**From:** Biazar, Shahab  
**Sent:** Wednesday, October 15, 2014 1:23 PM  
**To:** 'scott mcgee'  
**Cc:** Ortiz, Monica  
**Subject:** Erosion Sediment Control Plan For San Martin De Porres (M10E002)

Based upon the information provided in your submittal received 11-2-14, the Erosion Sediment Control (ESC) Plan for San Martin De Porres (M10E002) is not acceptable for building permit based on the following comments:

C-101

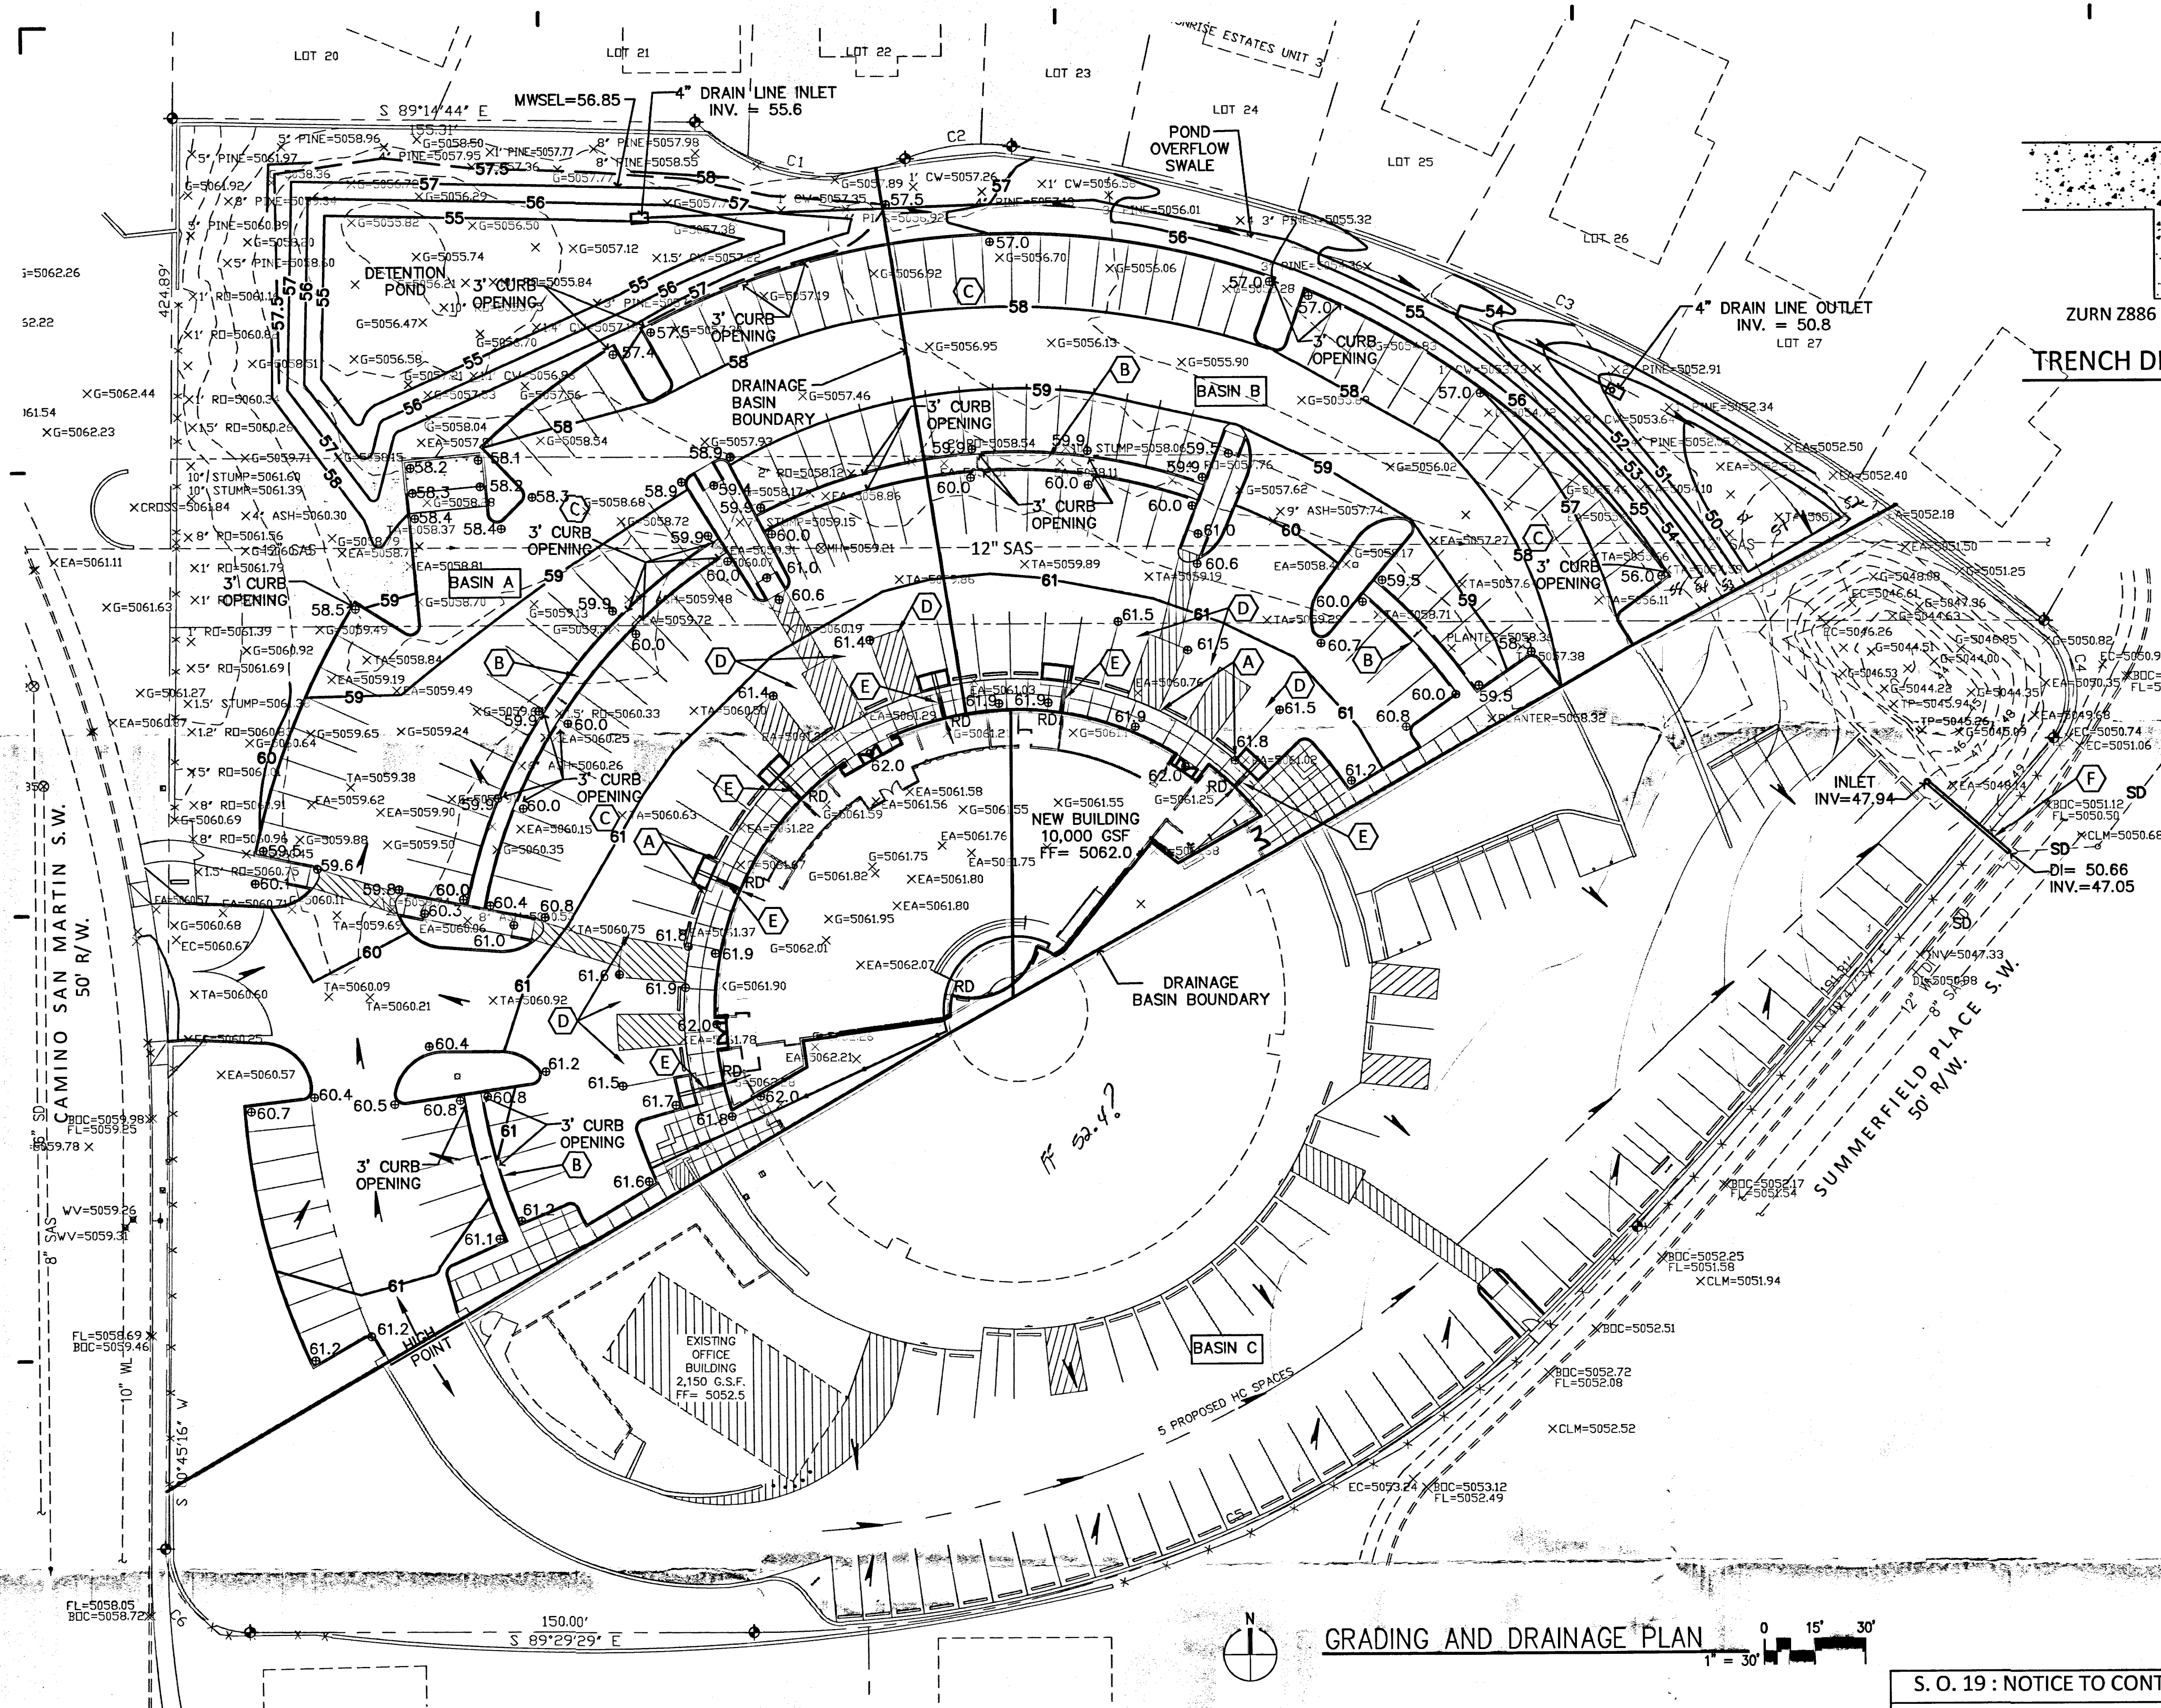
- Clearly show the Silt Fence locations.
- Include the location of the NPDES Posting Board (visible from Public right-of-way)
- Show the Staging Area.
- Include a note that "Project is required to maintain a regiment of street sweeping and clean up measures in the event of track out to minimize and prevent off site conveyances during construction."
- Provide stabilized construction entrance location and detail (depth should be 50' minimum)
- Provide details for all BMPs used on this site.
- Grading Plan must be approved prior to approval of the ESC plan.
